From: Robinson, KC <kc.robinson@aecom.com>
Sent: Friday, October 27, 2023 6:09 PM
To: Jeff Rice; terri.fead@state.co.us
Cc: sarah.houghland@state.co.us; stevenjacobsen@elpasoco.org; Mikayla Hartford; marta.blancocastano@state.co.us; Christina Prete; Marroquin, Leylin; Benenati, Tim
Subject: RE: Additional Data LOMR 22-08-0383P - Monument Hill Road Crystal Creek C

We have had some time to reivew the hydrology in the draft 2023 Jimmy Camp Creek Drainage Basin Planning Study (2023 DBPS). The large reductions in existing peak flows in the 2023 DBPS, when compared to previous studies (2015 Kiowa, 2003 City of Fountain, 1987 Wilson & Company, etc.) can be of concern that the risk of flood hazard may be under represented.

Figure 1-8. Annual Peak Flow Data at the USGS gage 07105900 from 1976– 2021

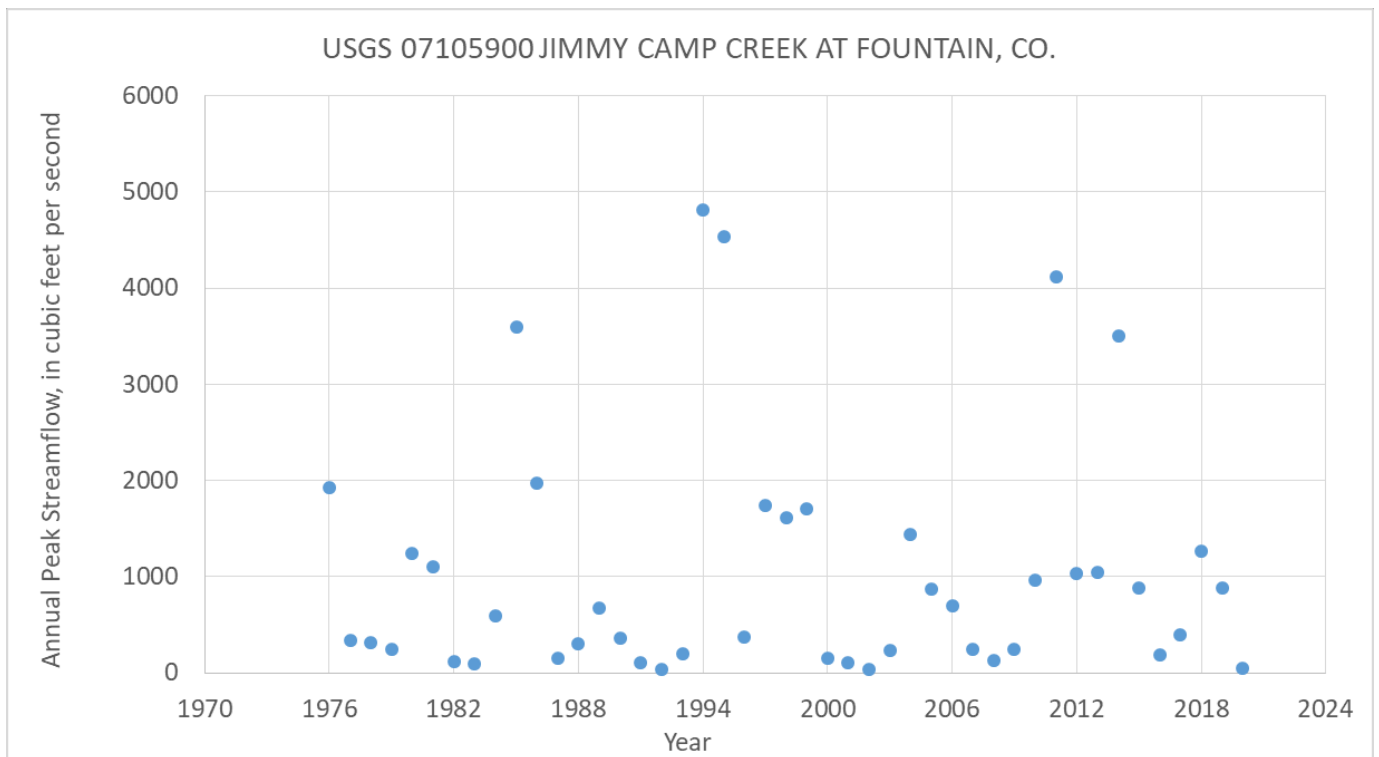
It follows that the 1965 event is quite extraordinary and indeed drives many local and regional "envelope curves" for extreme events from watersheds with drainage areas of 50 square miles and above. The 2023 DBPS chose to remove the 1965 event from their FFA which results in a much lower peak flow of 9,022 cfs (1%) and a negative skew to the fitted flow-frequency curve. Bulletin 17C does not treat high flow events that do not follow the trend of other data as "outliers". They are typically kept in the analysis with more effort used to characterize their rarity with non-exceedance information or other historic thresholds over long periods of time to better characterize how rare the event may have been, resulting in a better fit to the trend of the other measured data. Such paleo data or non-exceedance threshold information may not be available.
